Subject: Planning Proposal 3/2024/1028 Objections

Formal Objection to Planning Application

I am writing to formally object to the planning application 3/2024/1028 submitted by Ms Powell, for the proposed development at 4 Orchard Cottages, Branch Road, Waddington BB7 3HR. As a concerned resident, neighbour and member of the local Waddington community, I have several reservations about the potential impact of this development on the local area.

Proposed Ground Floor Plan
Scale (1 : 5 0)

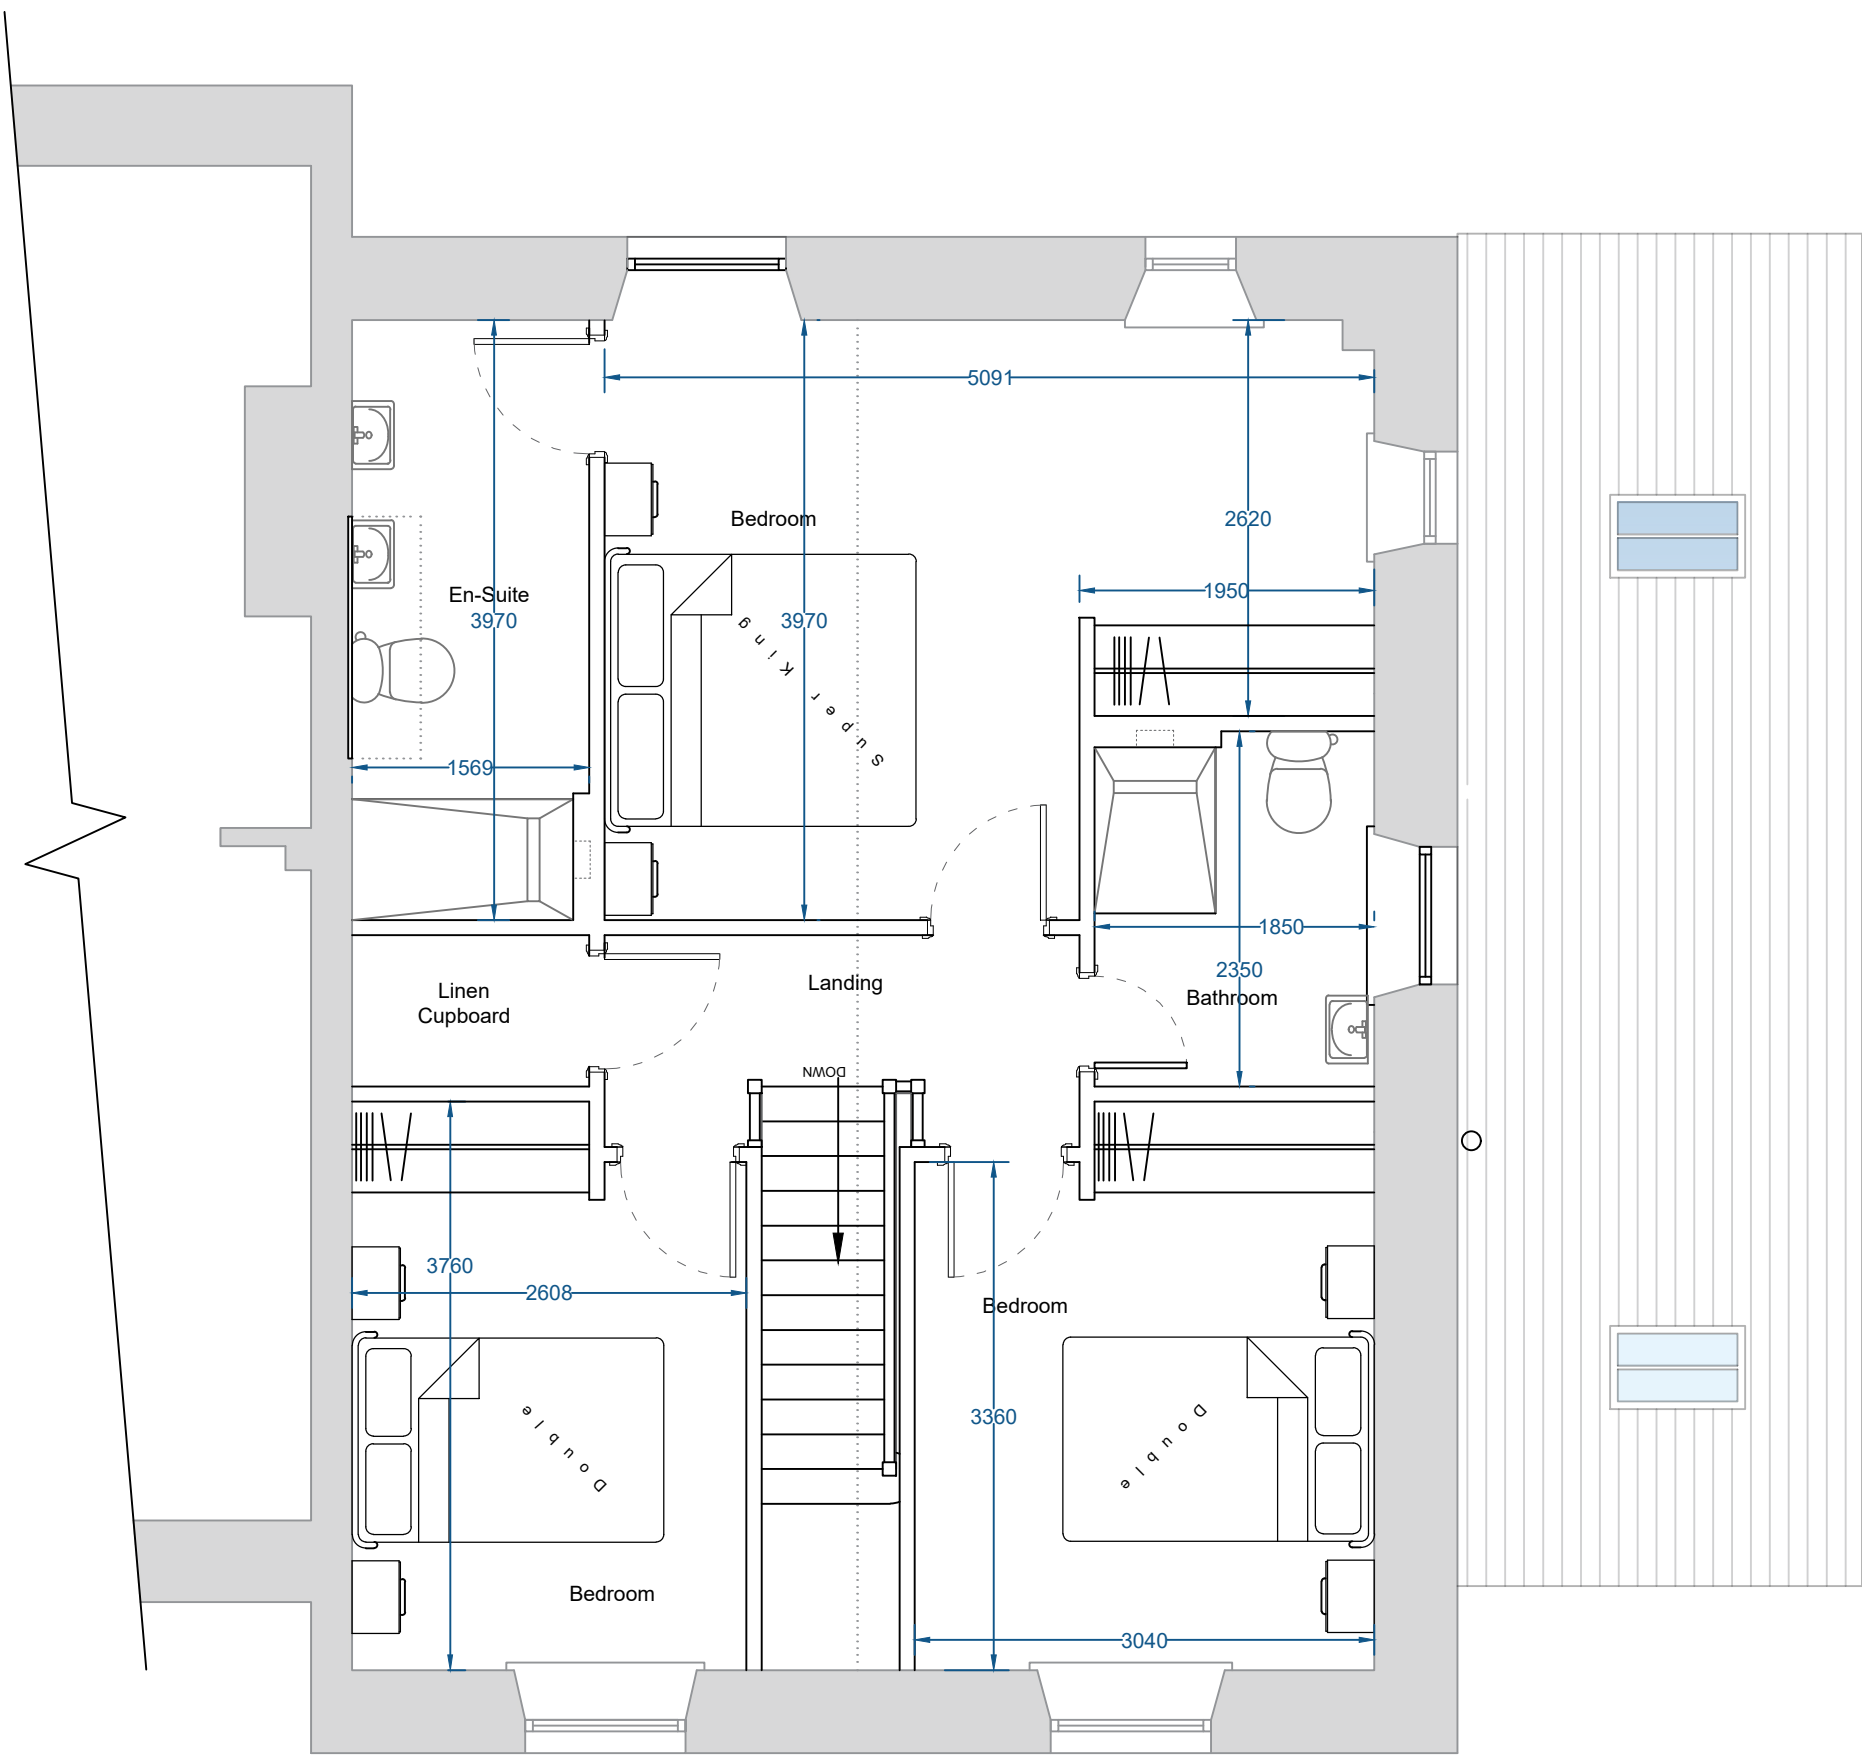
- The proposed single storey extension does not meet the conditionality stated in the appeal decision paper. None of the other 3 cottages have any such extensions and all have the same footprint. As such, this proposal sets a precedent that will adversely impact the architectural beauty and symmetry of the properties in the development. It is also at odds with other properties in the village close to the Orchard Cottages development
- 2. The proposed end elevation would mean that on entering the Orchard Cottages development, the proposed single storey extension will be the first thing to be seen. The onlooker would be faced with a large sliding window area which would provide views into the property, especially in the winter months. This is not compatible with other properties in the conservation area

Proposed Front Elevation
Scale (1 : 1 0 0)

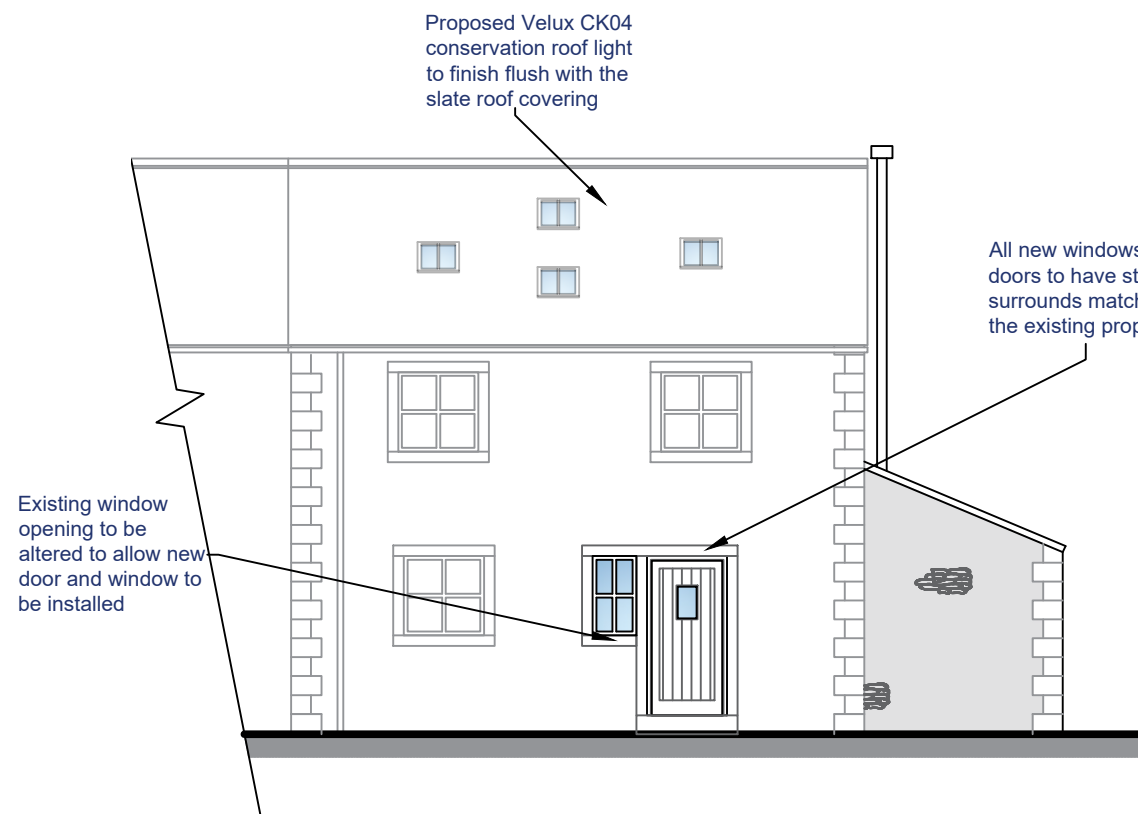
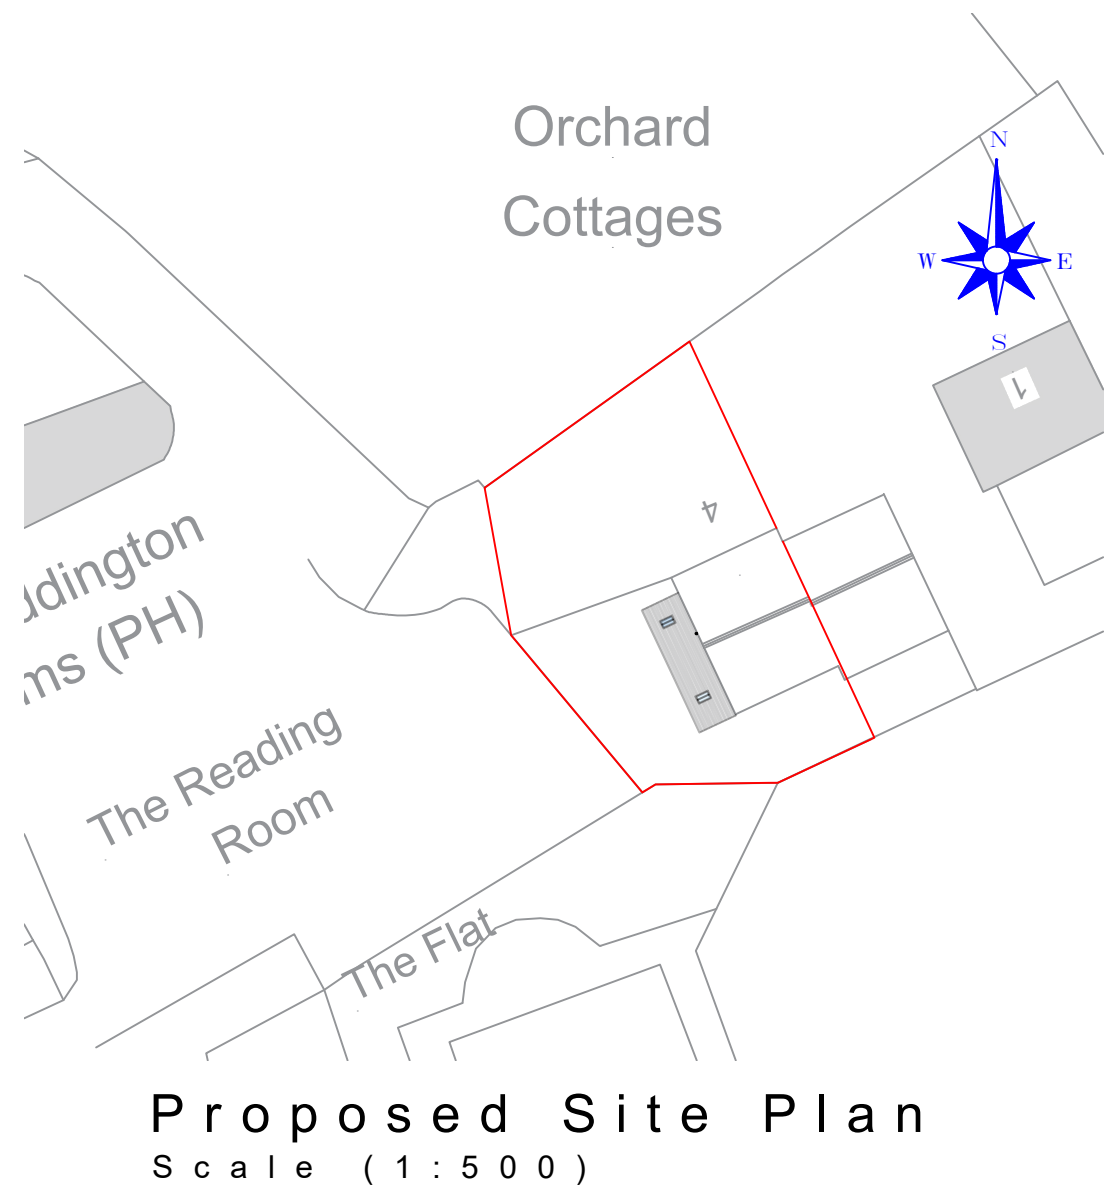
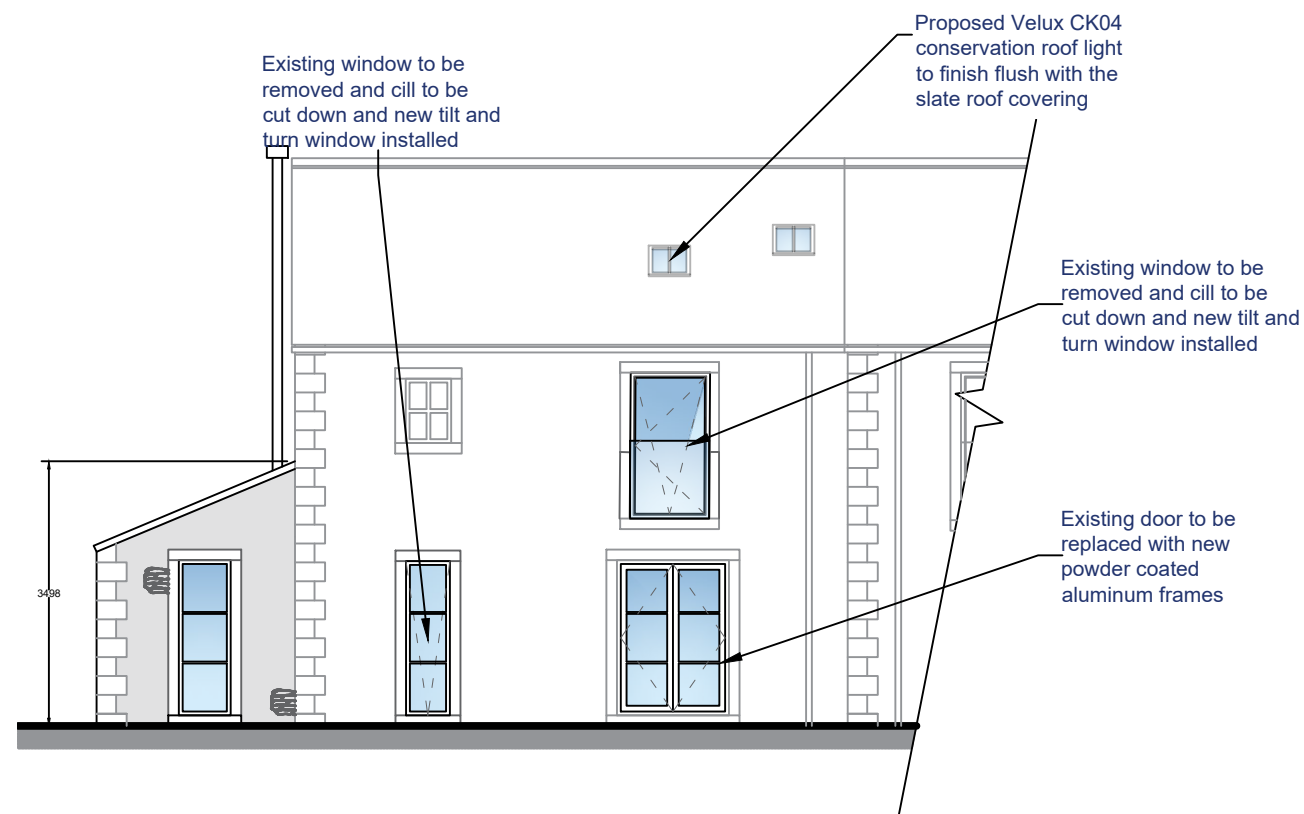
- 4. The single storey extension has a chimney flue visible on the end elevation above the extension itself. Again, this is one of the first structures to be seen on entering the development. It is not replicated elsewhere in the development nor is it sympathetic to local properties. In short it is an eyesore that is clearly visible to all

- 6. The proposed front elevation is not in keeping with the front elevations of the other 3 cottages in terms of window locations. To retain the character of the architecture of the development, the front elevation should match that of the other properties.

- 7. The single storey extension will adversely impact the symmetry of the front elevation when compared with the other 3 cottages.
- 8. Parking Spaces for the property the deeds for number two parking spaces and a reversing area in the garden adjacent to the side elevation of the property. To date, these have not been utilised resulting in additional parking congestion on the access road into the Orchard Cottage development. If this parking and turning area was/is enacted, it would help alleviate this congestion. In addition, it would also prevent the erection of the single storey extension, proposed for the side elevation.
